City of Portland, Maine - Building or Use Permit

Permit No: 10-0744	Date Applied For: 06/29/2010	CBL: 039 G002931
-----------------------	---------------------------------	---------------------

Proposed Use: Townhouse - 4 residential condos (Unit 1) interior reno, kitchen, wood floors, new stair to 3rd floor within unit, add floor area to existing stair opening on 3rd fl	Proposed Project Description: Interior reno, kitchen, wood floors, new stair to 3rd floor within unit, add floor area to existing stair opening on 3rd fl
--	--

# 2ND FLOOR UNIT 1

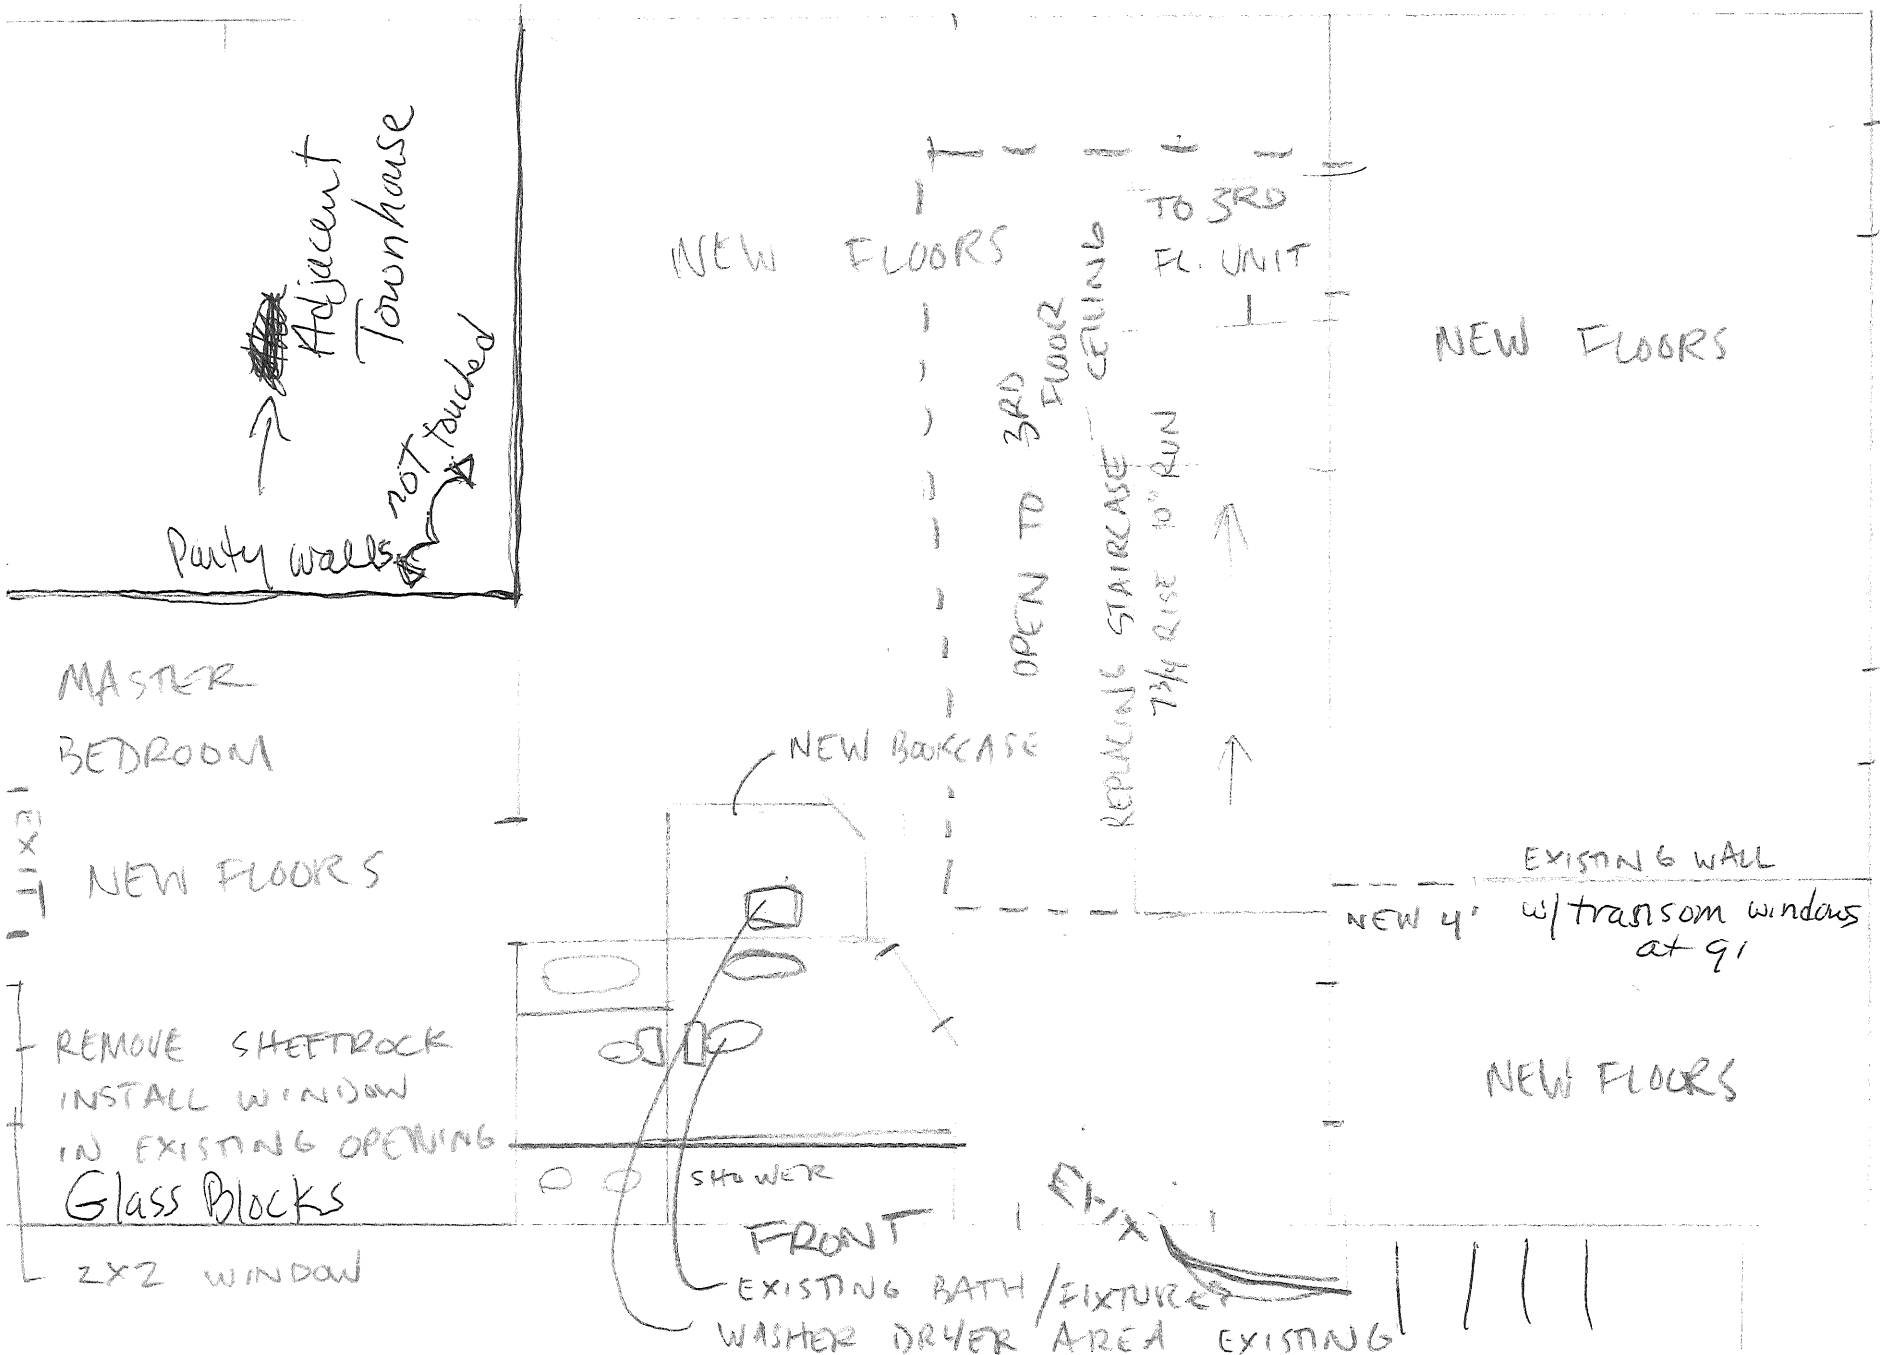
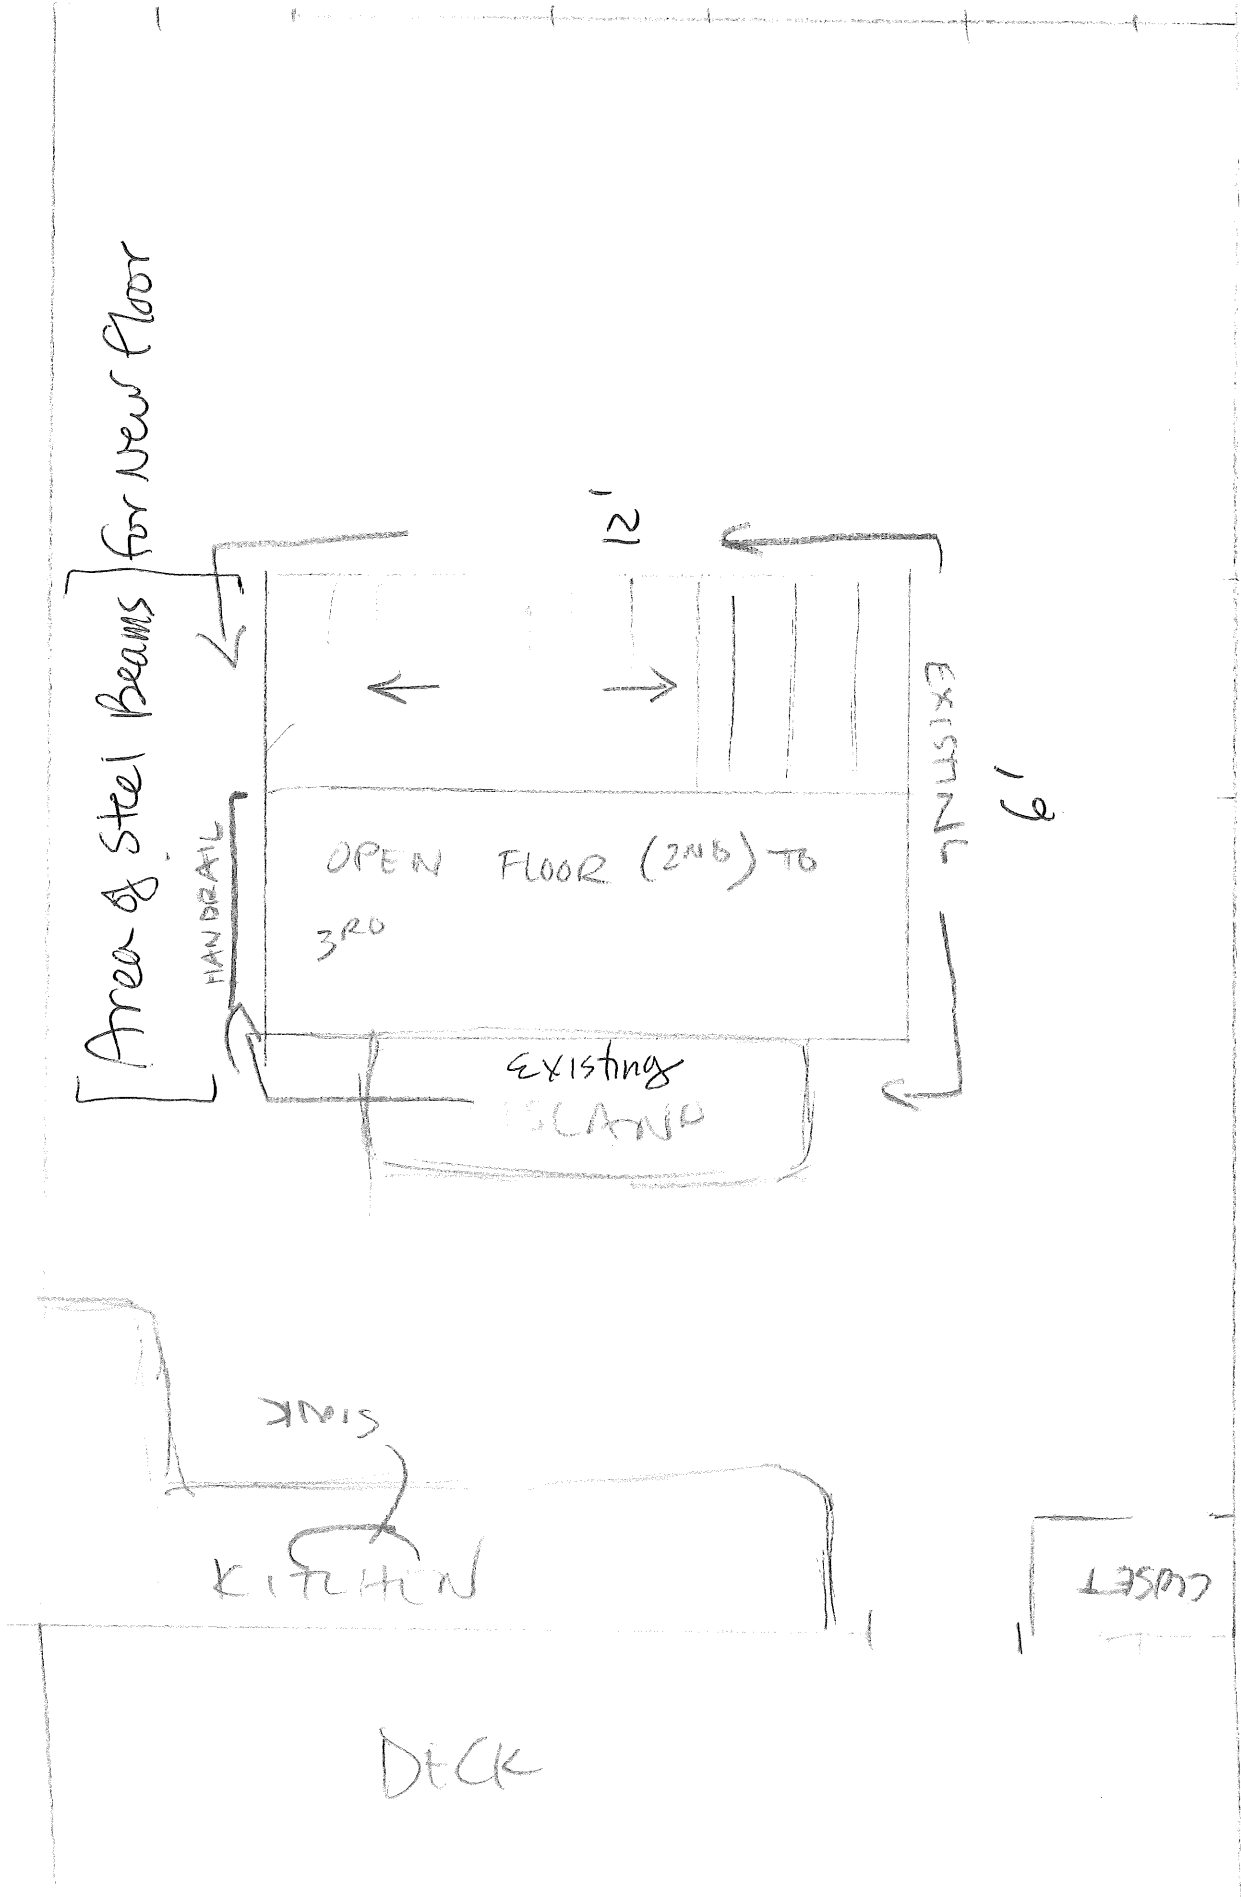
6/30/2010-jmb: Spoke to Matt F. The contractor for details on the new steel beams and floor, railing details around the opening and on the new stairs. The new stairs were fabricated in steel as part of the new I-beams for a landing/floor above. The landing may end up being glass, specs are required. Matt will email the framing details. Received the drawing.

7/1/2010-jmb: Spoke with Raphael D. As we need the right title and interest of this newly purchased property. Also discussed conditions for details to be submitted for the glazed railings and possible the floor landing. He will submit.

Dept: Building	Status: Approved with Conditions	Reviewer: Jeanine Bourke	Approval Date: 07/01/2010
Note:	Ok to Issue: <input checked="" type="checkbox"/>		
<ol style="list-style-type: none"> 1) All penetrations through rated assemblies must be protected by an approved firestop system installed in accordance with ASTM 814 or UL 1479, per IBC 2003 Section 712. 2) Details shall be submitted for the glass panel railings and possible glass floor landing prior to their installation. 3) Those renovating dwellings shall install a CO detector in each area within or giving access to bedrooms. That detection must be powered by the electrical service in the building and battery. 4) Permit approved based on the plans submitted and reviewed w/owner/contractor, with additional information as agreed on and as noted on plans. 5) Separate permits are required for any electrical, plumbing, sprinkler, fire alarm HVAC systems, heating appliances, commercial hood exhaust systems and fuel tanks. Separate plans may need to be submitted for approval as a part of this process. 6) Application approval based upon information provided by applicant. Any deviation from approved plans requires separate review and approval prior to work.
